CITY OF ALBUQUERQUE

**RE: Los Pastores Shopping Center & McDonalds
Montgomery/Wyoming
DMP Addendum 3
Engineers Stamp Date: 3/26/2019,
Hydrology File: F19D013C & F19D013A**

Based on the information provided in your submittal received on 3/26/2019 the DMP Addendum cannot be approved until the following comments are addressed.

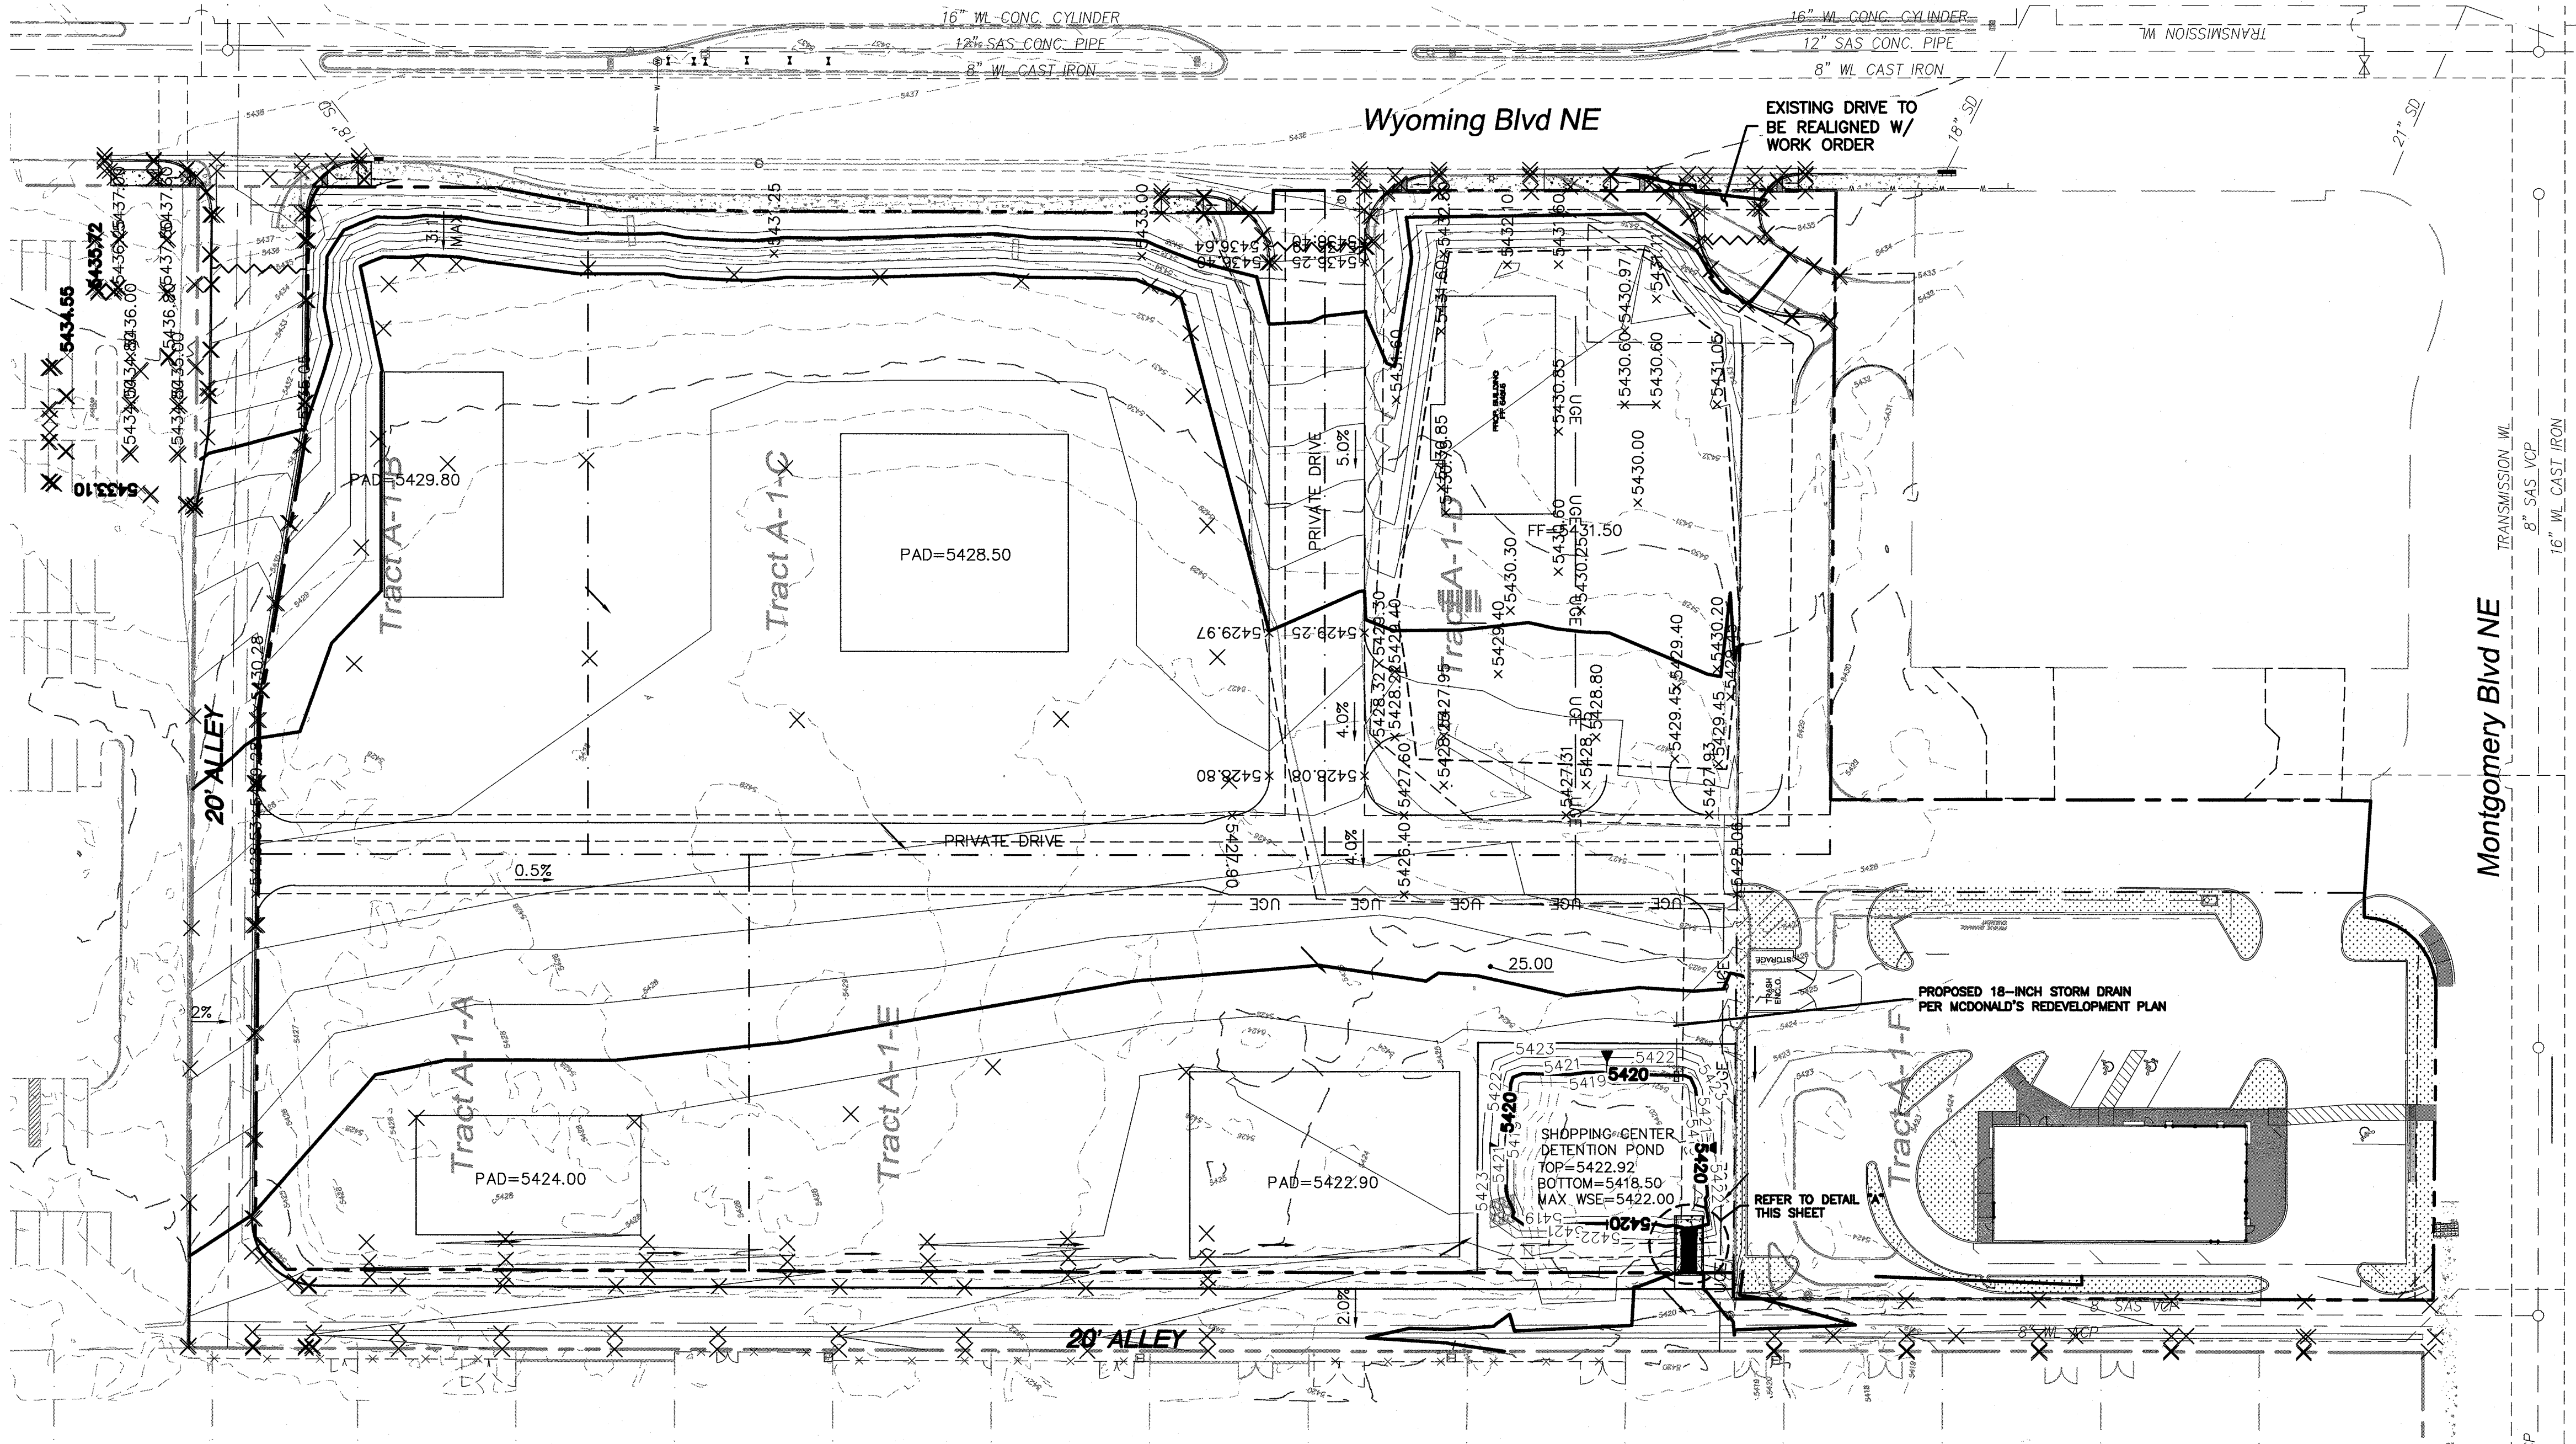
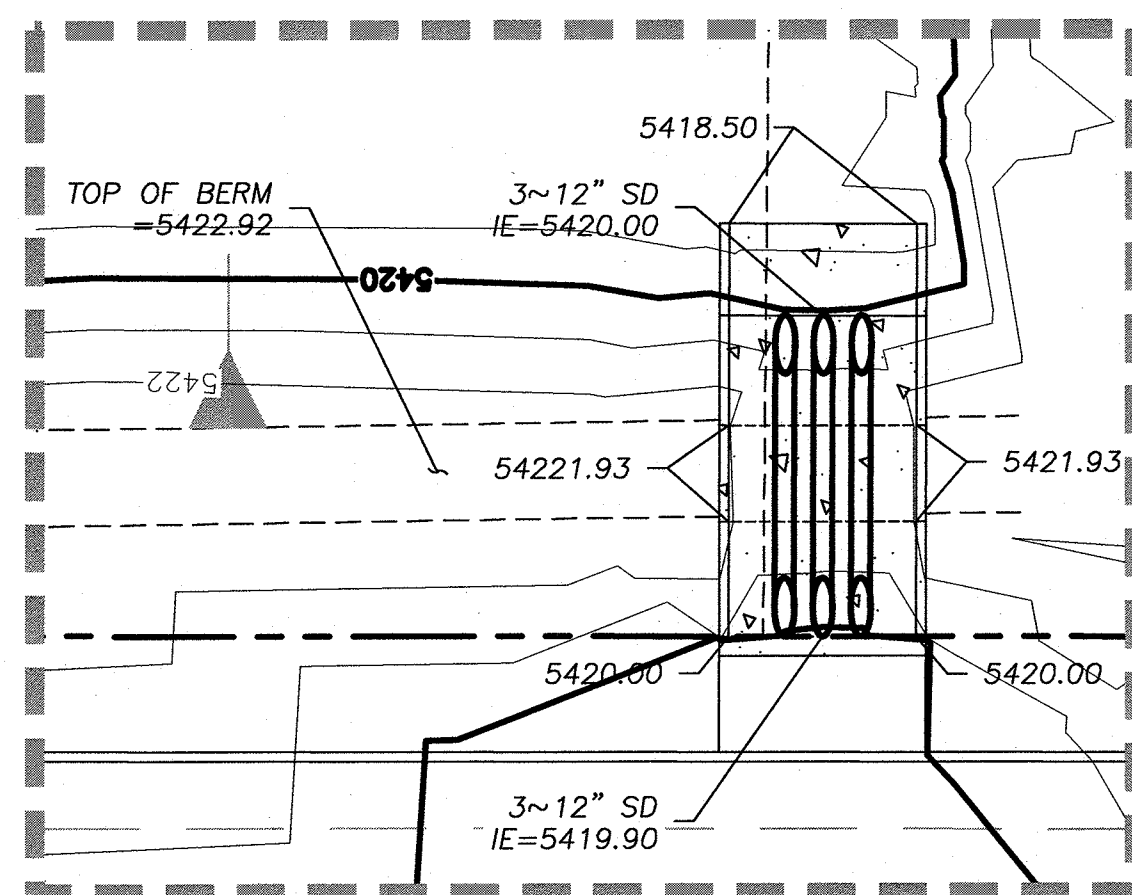
6. Please label the contours better on the pond grading detail. The bottom of the pond, Elevation 5418.5, appears to be 70' x 55' and the top, elevation 5421.93, is 88' x 73' but the area used in the volume calculations for the top of the pond is larger by about 5' in each direction. Please resolve the discrepancy by either changing the volume calculations or by changing the drawing.

13. Show the calculations of the required SWQV and include a statement next to the pond on sheet GR-1 specifically identifying which impervious surfaces are being served.

14. Add a note on Sheet GR-1 near the pond stating that the pond is already constructed as shown on the plan and that no new pond construction is proposed. Provide an engineer's stamp and signature on sheet GR-1.
